Planning Services Sign Permit Review Form

Date of Submittal	Application Number	Applicant	Landowner
04-03-19	SIGN1904-0001	Anchor Sign, Inc	ARC FD34PCK001, LLC
Contact Person	Contact Number	Sign Location	PIN Number
Jill Hopkins	843-576-3241	1681 Buffalo Lake Rd	9586-77-3974

Comments	3 total wall signs; 1 change of sign face
----------	---

**Front Elevation (Northwest)**

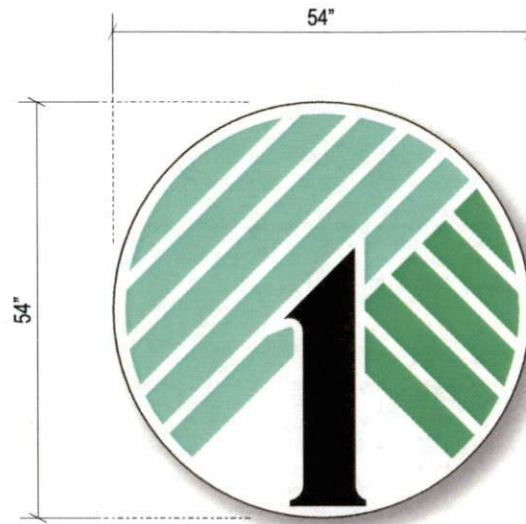
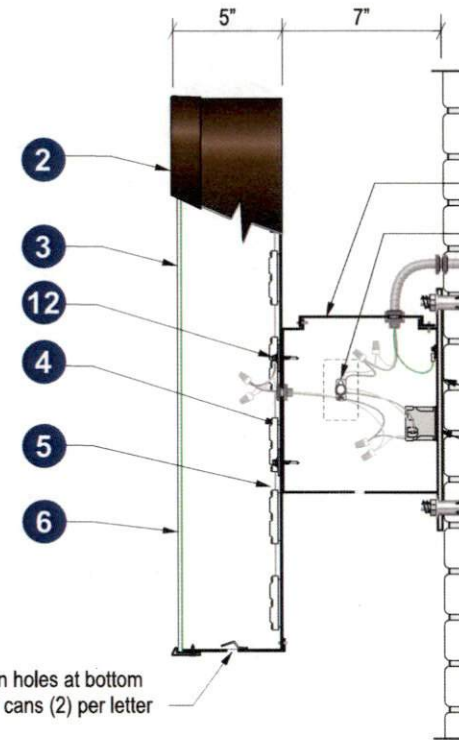
① Northwest facade
 16'3" wide wall face
 54" sign diameter
 $A = \pi r^2$
 $A = \pi 2.25^2$
 $A = \pi 5.0625$
 $A = 15.89625$ sq. ft.

**Left Elevation (North)**

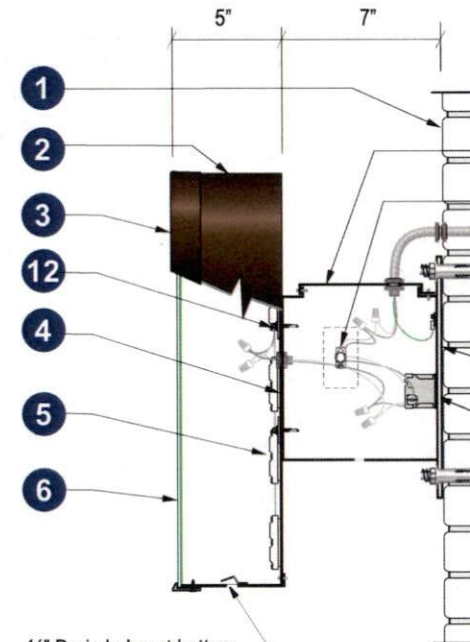
② North facade
 ~70' wide wall face
 $= 30" \times 26'8\frac{3}{4}"$
 $= 2.5' \times 26.73'$
 $= 66.825$ sq. ft.

**Right Elevation (Southwest)**

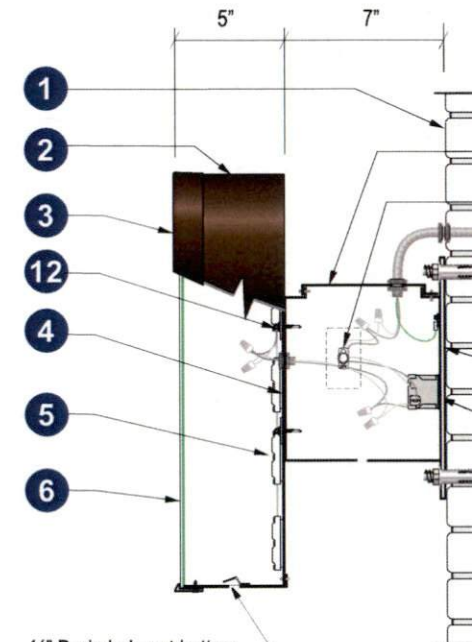
③ West facade
 ~95' wide wall face
 $= 30" \times 26'8\frac{3}{4}"$
 $= 2.5' \times 26.73'$
 $= 66.825$ sq. ft.
